Drafted 28 December 2011

**Planning Application, Ribble Valley District
3/11/0980 Eastham House Farm, Clitheroe Road, Mitton**

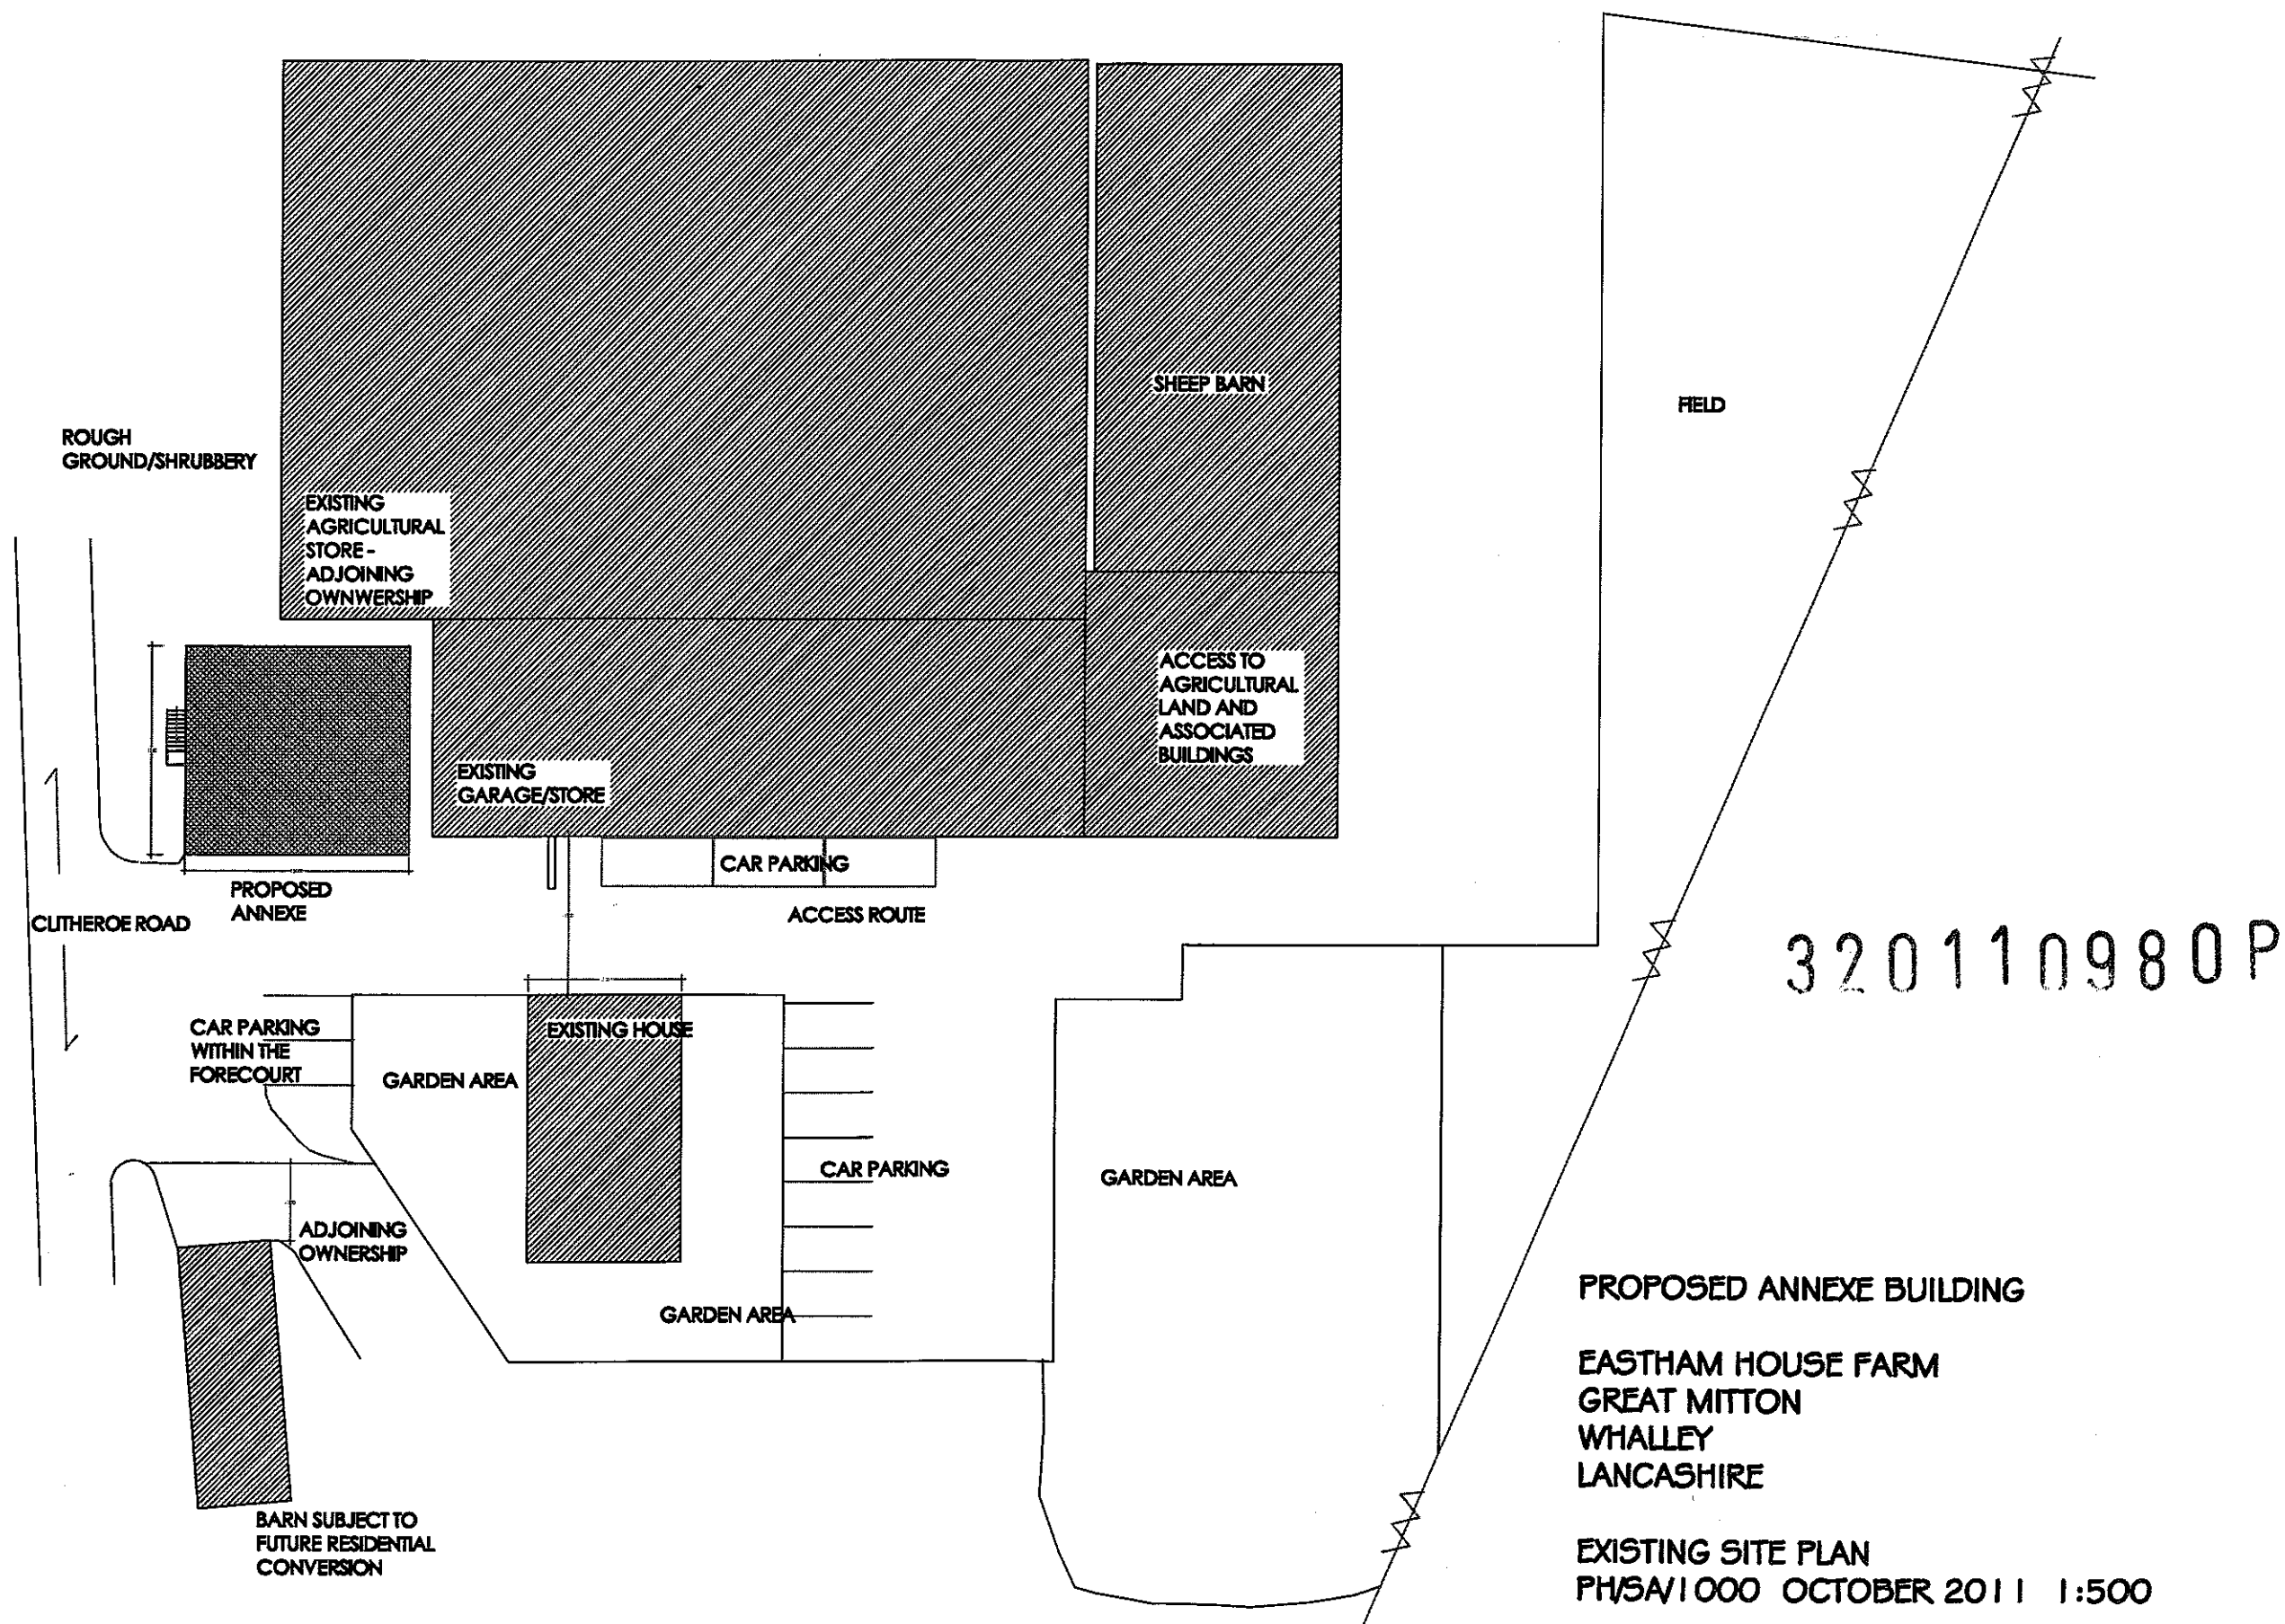
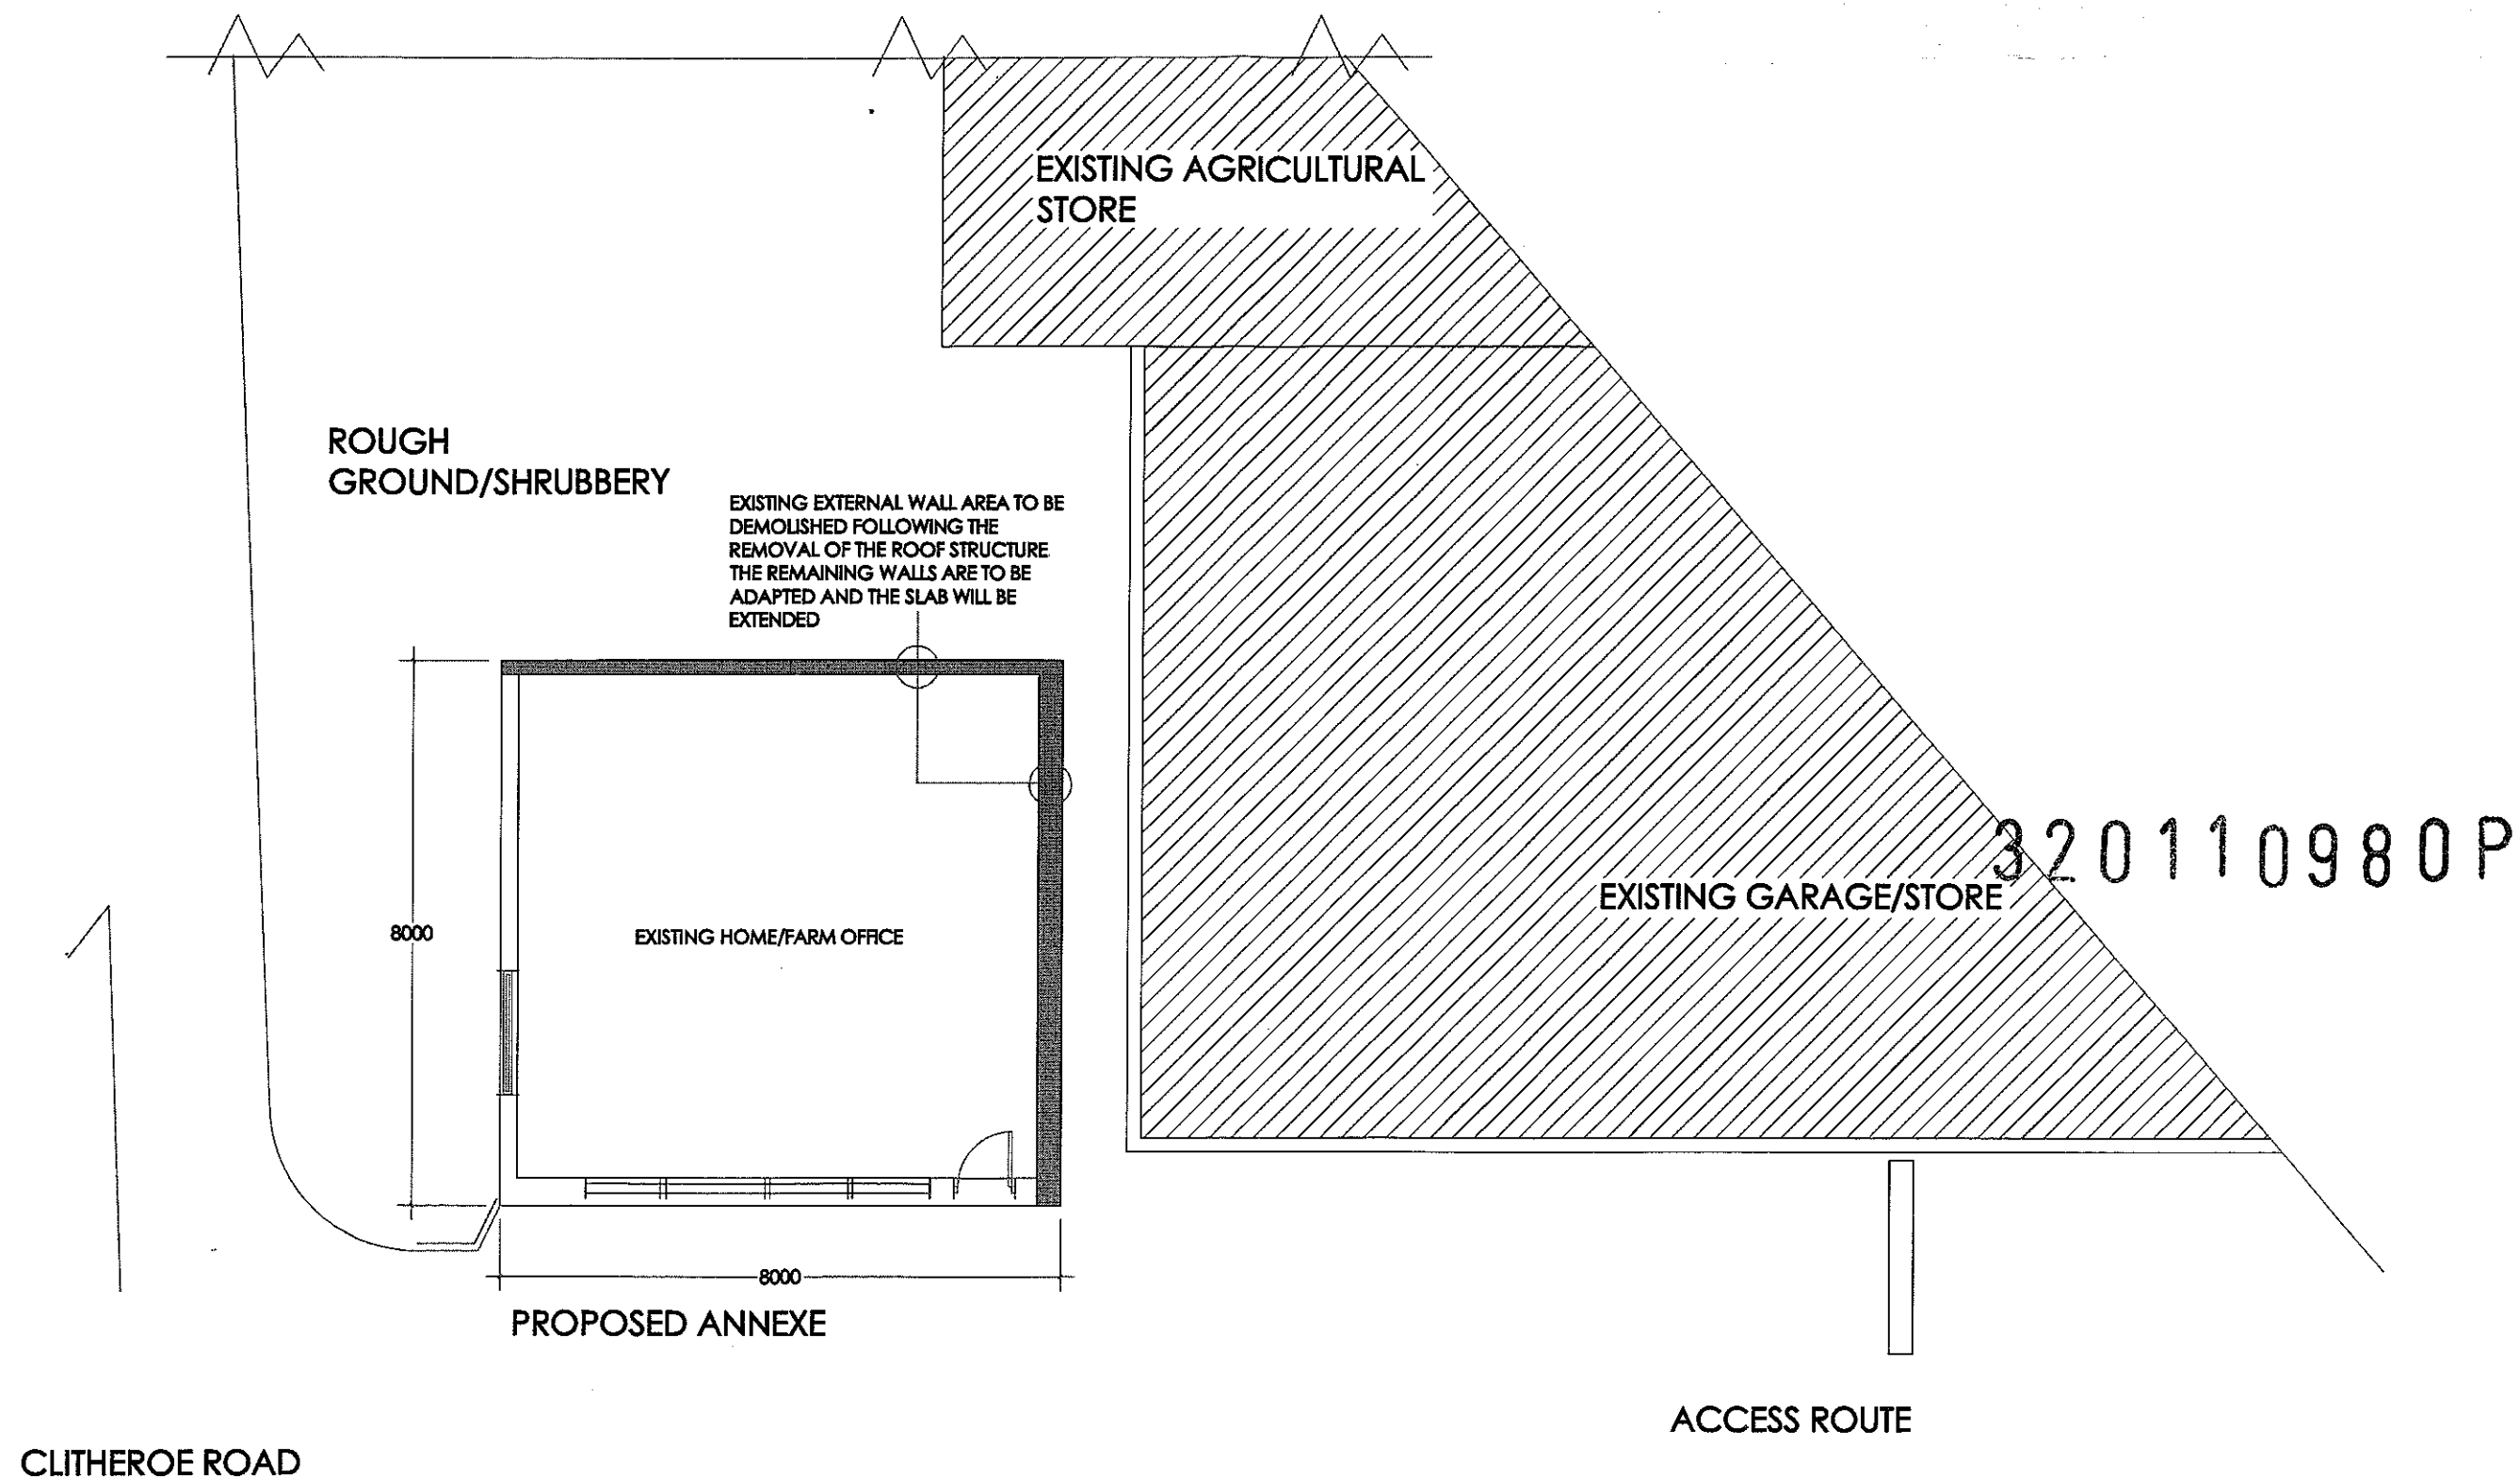
While there is no change proposed to the overall provision of parking within the site, I would recommend that the two spaces shown to the south of the proposed annexe be allocated for its use. Furthermore, in order to improve the safe operation of these spaces, they should be realigned so that manoeuvring takes place from the service road, rather than directly to or from Clitheroe Road. While this is a minor recommendation, it will have a direct benefit on the safe functioning of the site and for the operation of the annexe in particular.
